## **AQUIND Interconnector**

### **Application by AQUIND Limited for an Order Granting Development Consent**

#### **Local Impact Report**

#### **Hampshire County Council**

Appendix 2 – Converter Station Access Drawing

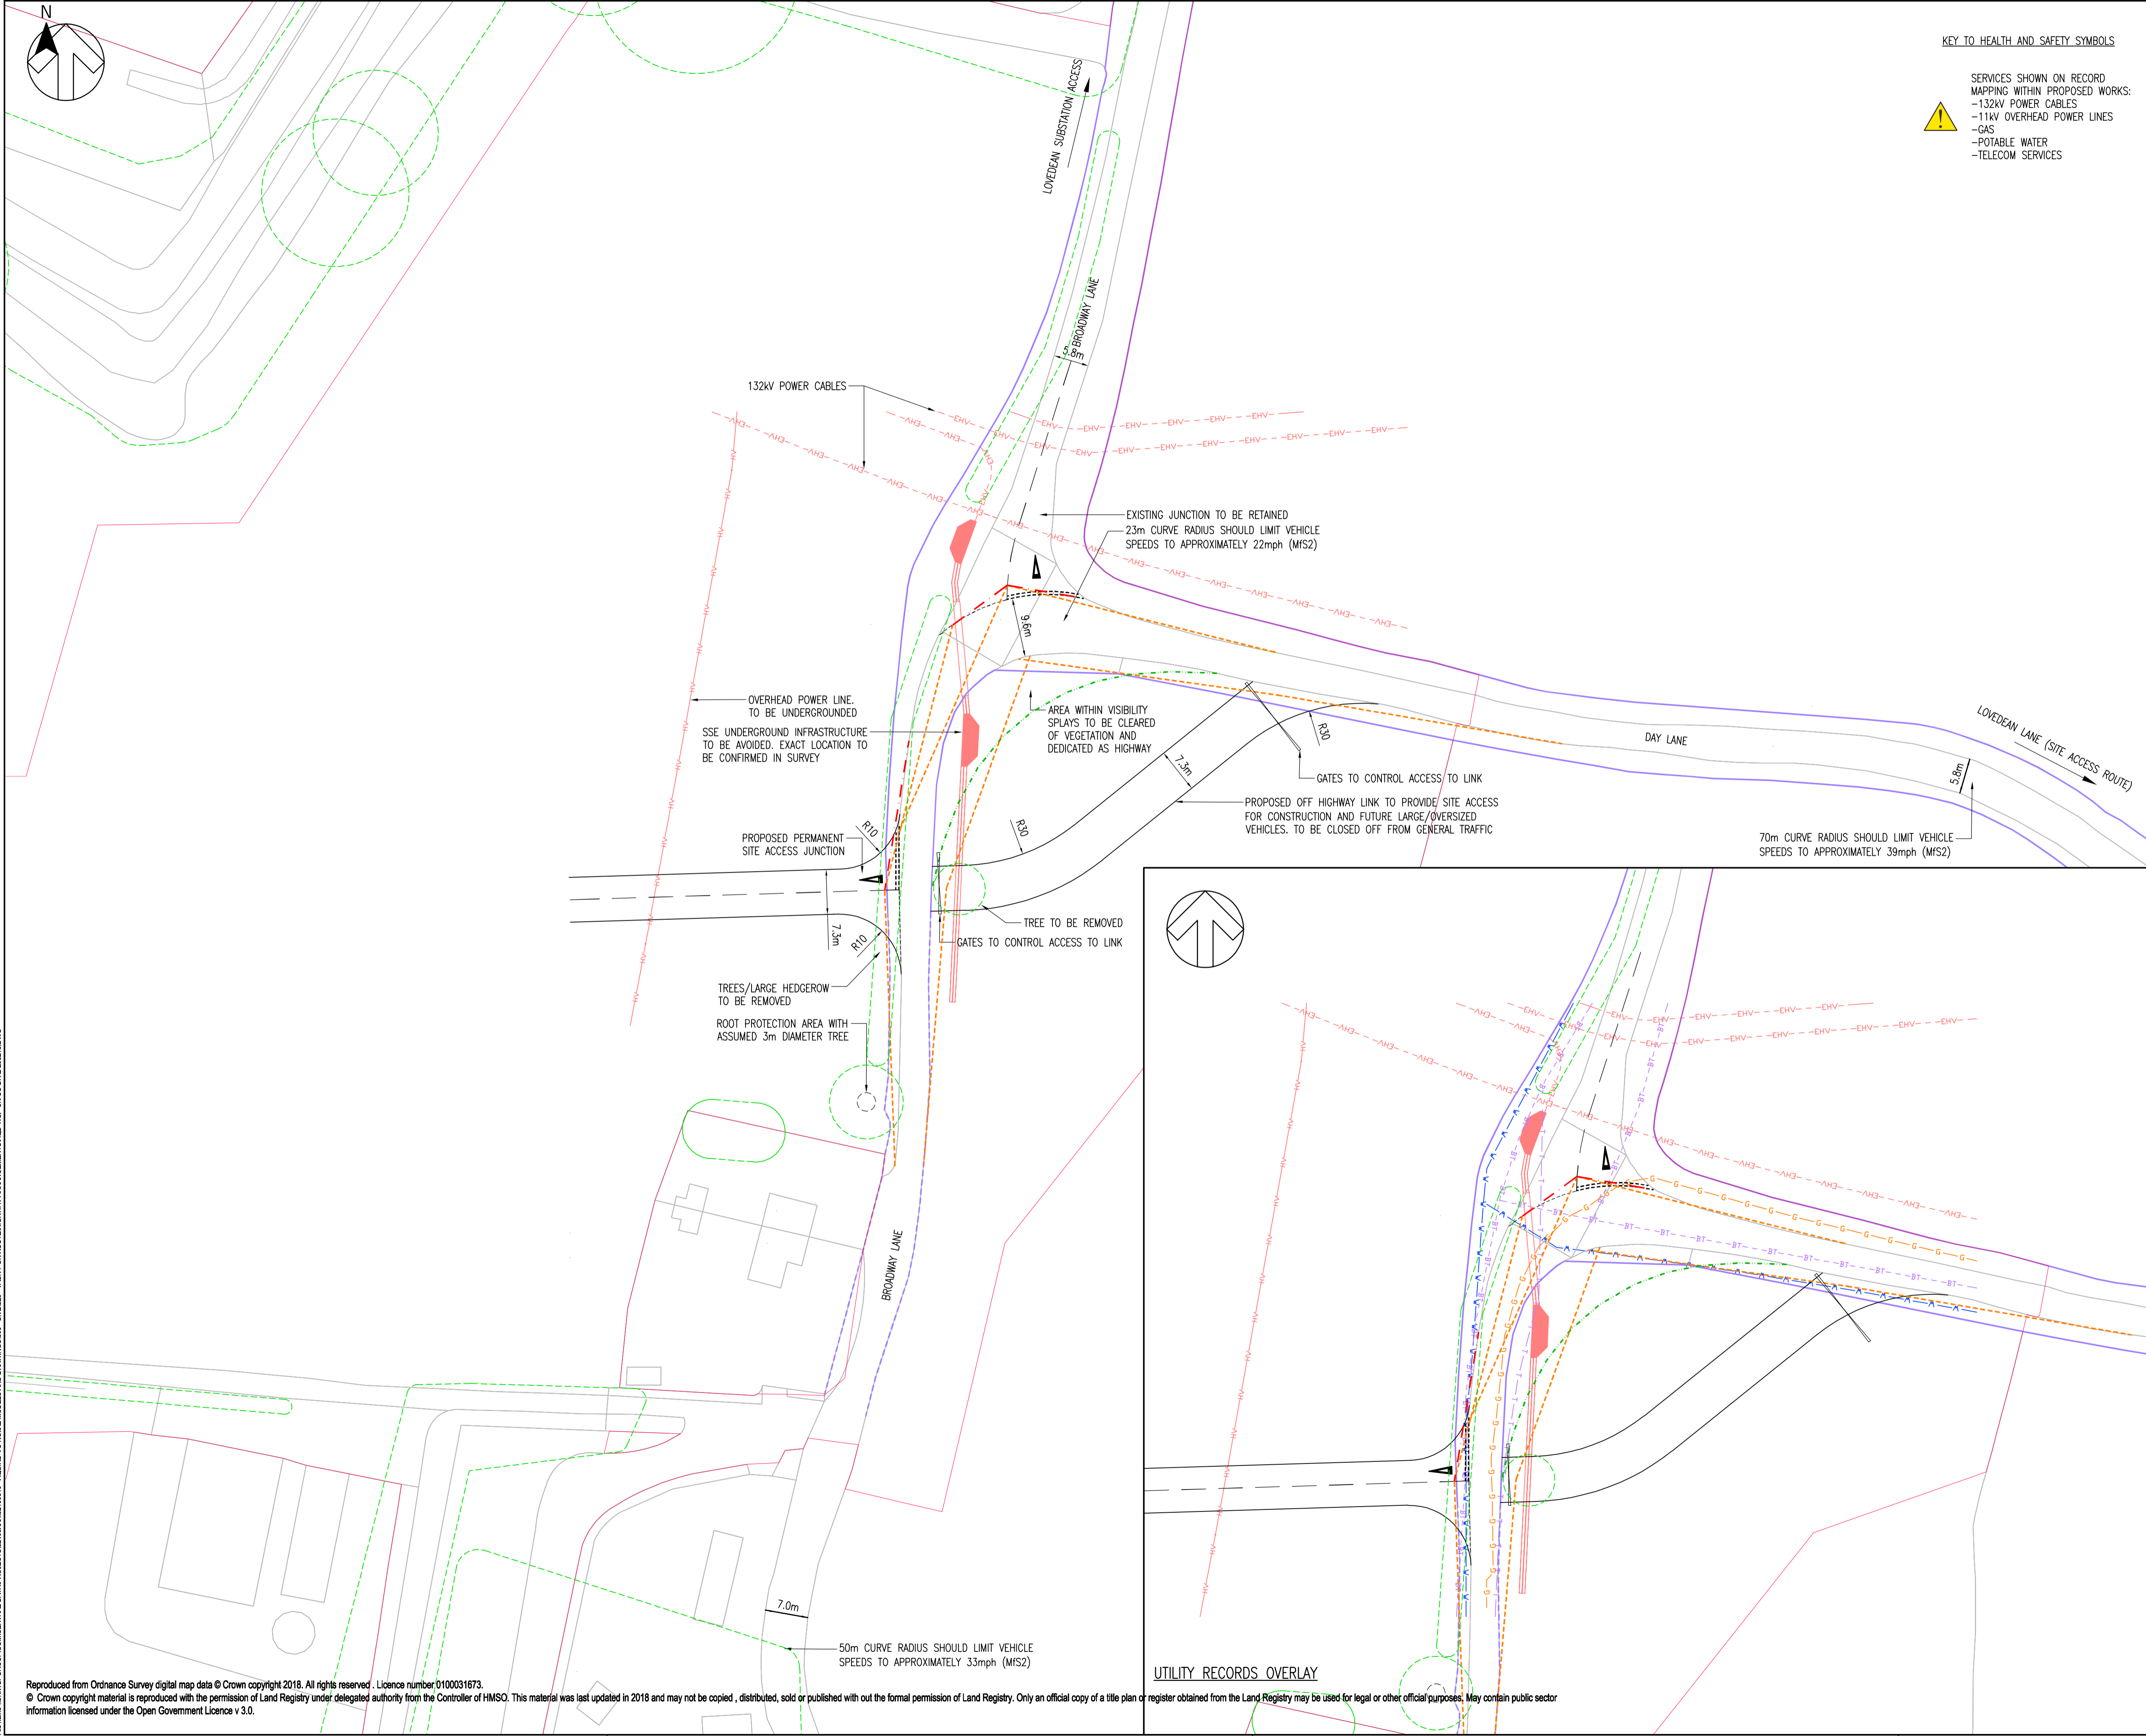
- 5.10 This area of work is mainly off-highway through the converter station site. The highway works associated with this section are the site access works, for which comments have been provided in paragraph 5.37-5.41 and Appendix 5. Insufficient information has been submitted, to date, on the potential impact on Horndean Footpath 4
